# PORTLAND MAINE

July 20, 2009

RE: 90 Crescent Avenue, Great Diamond Island - #083A-E-007 – IR-2 Zone – Permit  
#09-0584

SITE PLAN-TOPOGRAPHY PLAN
LAND OF DOUGLAS S & KATHY SUE ROBERTS & NANCY JO CONNOLLY
CRESCENT AVENUE - GREAT DIAMOND ISL.
PORTLAND, MAINE 04109
DOUGLAS S & KATHY SUE ROBERTS & NANCY JO CONNOLLY
HERBERT P. GRAY
111 SIMMONS ROAD, SOUTH PORTLAND, MAINE 04106

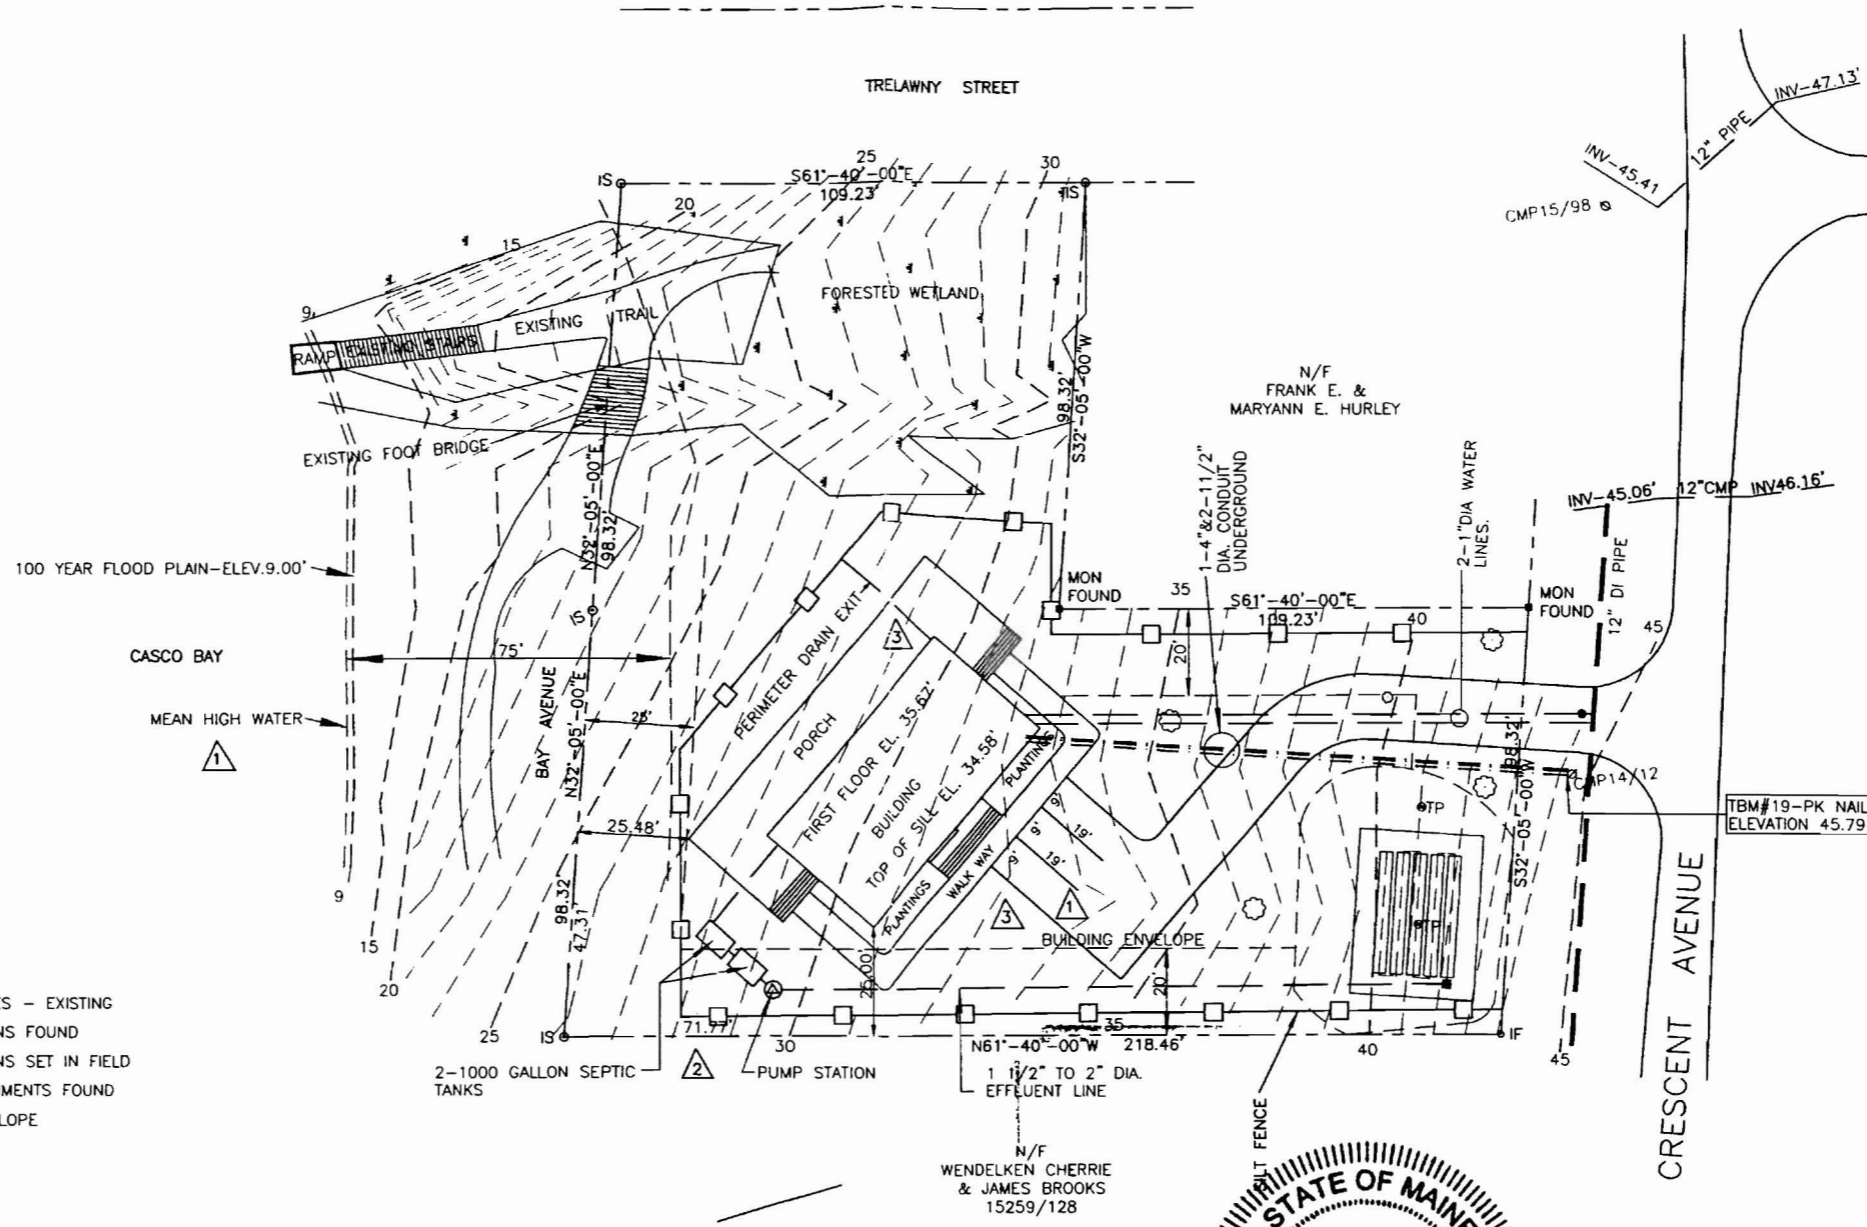
Please note that the permit to add an accessory dwelling unit to the previously approved single family dwelling, was approved by the Zoning Board of Appeals on July 16, 2009. Please note that I need a clarification from you or the surveyor as to what portion of the site is going to be permanently cleared. Please note that the previous Shoreland Zoning requirements (under which this permit was reviewed) stated that "In no event shall cleared openings for development, including but not limited to, principal and accessory structures, driveways, and sewage disposal areas, exceed in the aggregate, 25% of the lot area or 10,000 square feet, which ever is greater". Your plans do not fully depict this area.
